Your Ref: OWPC20131
Our Ref: R/190/18/PL 31-07-2018
Please ask for:
Mrs A Gardner

Demolition of 1 No. existing house & grounds & erection of 2 No. new detached dwellings. This application may affect the character & appearance of the Station Road, East Preston Conservation Area.
St Marys Close Hurst Road Rustington

Thank you for your internet representation made on 8th October 2018 which has been recorded as '**an objection**' with the comments as follows:

Drawing Title:
ADDITIONAL DWELLING
PLOTS 1 & 2
ELEVATIONS

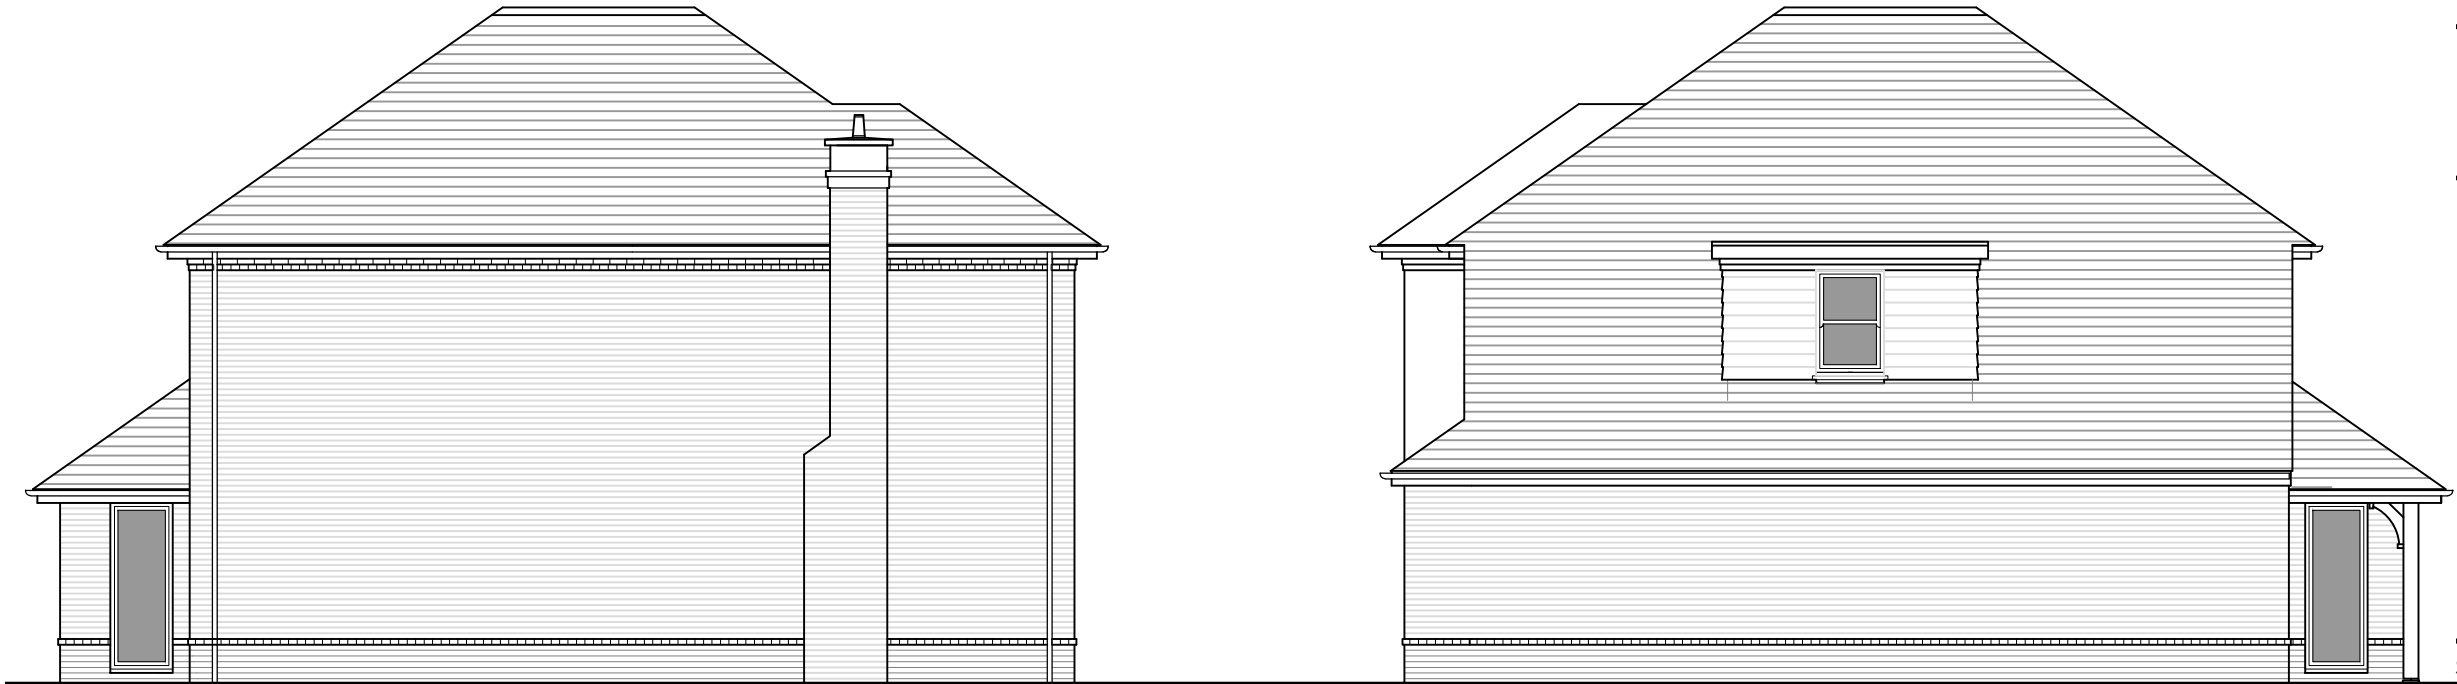
We would like to object to the application R/190/18/PL on the basis that two identical houses would be out of character and detrimental to the street scene of Hurst Rd. The road is characterised by a variety of styles of housing with no two the same, even the most recent additions to the road, numbers 1&2 The Cedars are of different design.

We hope that until both houses have a more individual design this application will be refused.
